Consultation Response from KC, Highways Development Management		
2020/91889 Former North Bierley Waste Water Treatment Works, Oakenshaw, BD12 7ET		
Discharge condition 20 on previous permission 2016/92298 for outline application for re-development of former waste water treatment works following demolition of existing structures to provide employment uses (use classes B1(c), B2 and B8)		
Date Responded:28/07/2020	Responding Officer: Mark Berry	Responding Ref: 7-12NE-10

This application seeks approval to the discharge condition 20 on previous permission 2016/92298 for outline application for re-development of former waste water treatment works following demolition of existing structures to provide employment uses (use classes B1(c), B2 and B8) at the former North Bierley Waste Water Treatment Works, Oakenshaw.

Condition 20. No more than 17,642m² of floorspace shall be constructed until either:

- a. the highways works on the Bradford Road approach to M62 Junction 26 Chain Bar, as shown in principle on AECOM drawing number 60221630 Rev 5, are approved in writing with Kirklees Council in consultation with Highways England; or
- b. the improvement scheme to remove M62 westbound to M60

No. 60221630					Rev: 5

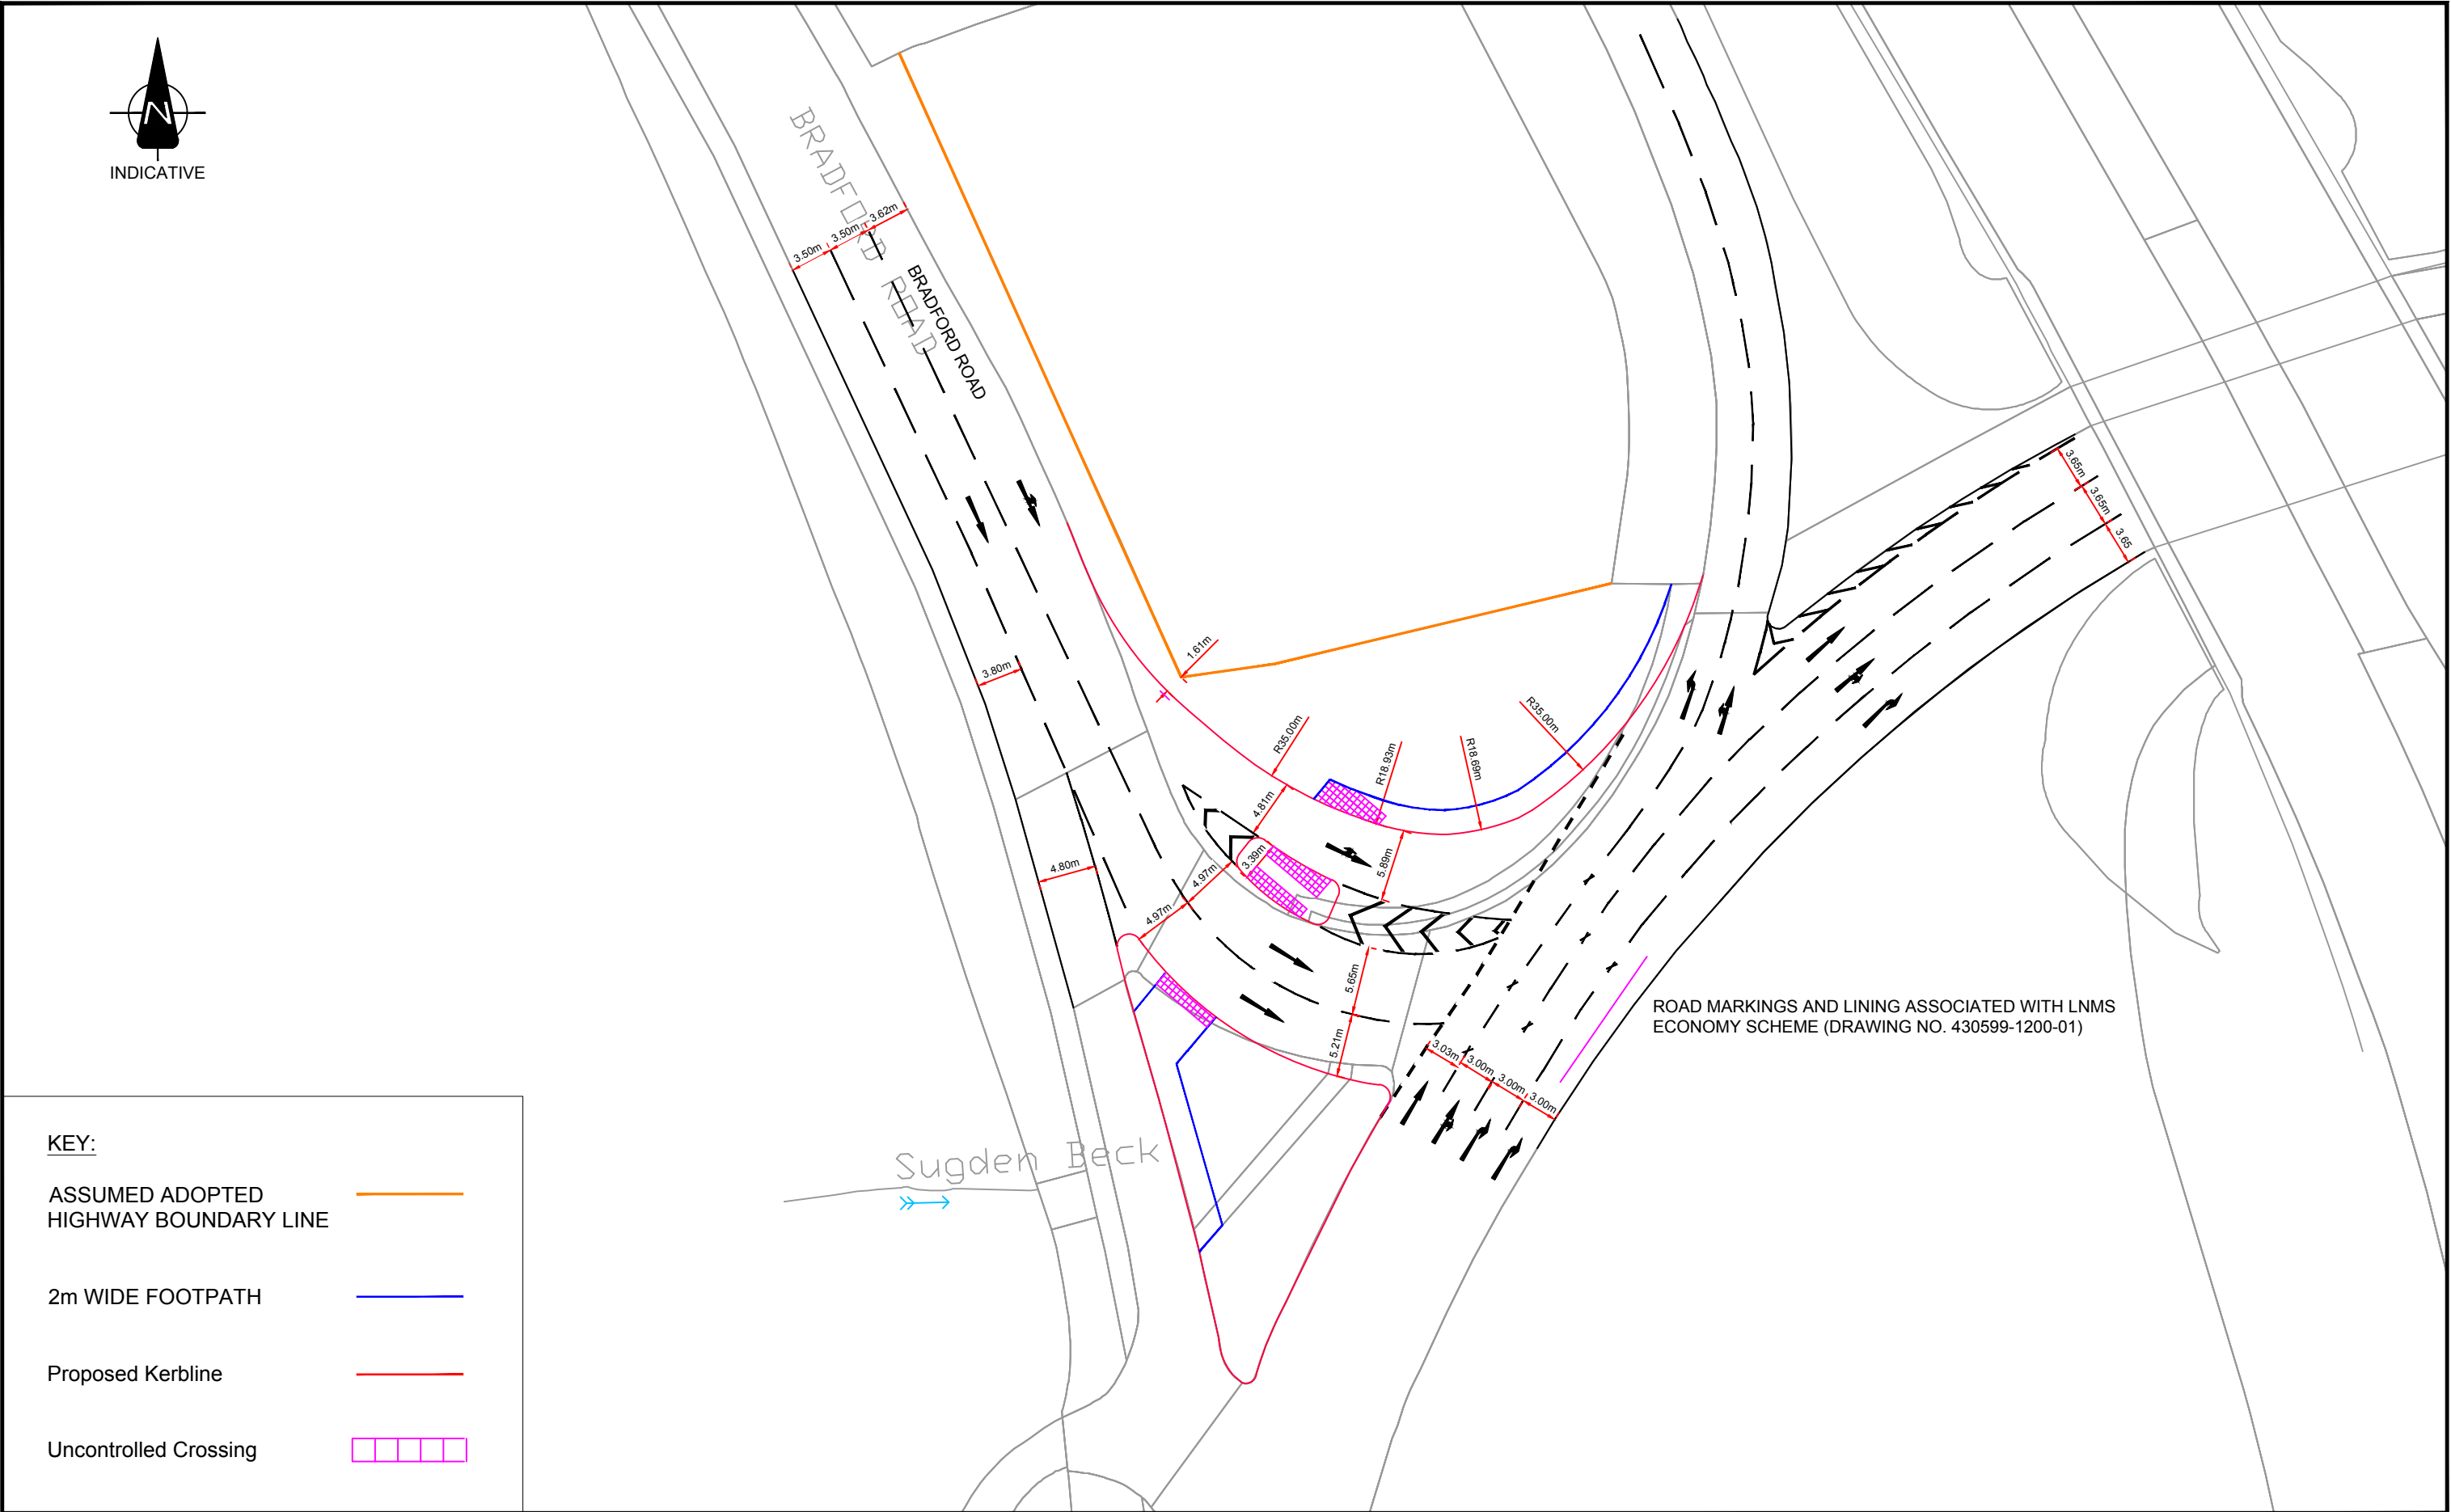
The stage 1 road safety audit should be provided

LOOK LEFT / LOOK RIGHT markings are needed to the pedestrian crossing points.

A double white line system and studs between the northbound & southbound lanes should be considered. Highways Safety report that they have knowledge of an issue with collisions involving vehicles exiting the roundabout onto this leg, and double white lines & studs may assist. This could terminate where the central hatching starts prior to reaching the golf course access and would remove the need for the existing diagram 1014 deflection arrow.

A text to supplement the proposed lane arrows should be provided.

A new 'lane arrows' Advance Direction Sign should be considered.

The existing lane text markings needs refreshing.

The existing footway on the approach to the roundabout incorporates a cycle lane. The new footway does not extend as far into Bradford Road as existing. Can this be extended.

The saplings which have grown up in front of the 2 Advance Direction Signs on the junction approach should be removed.
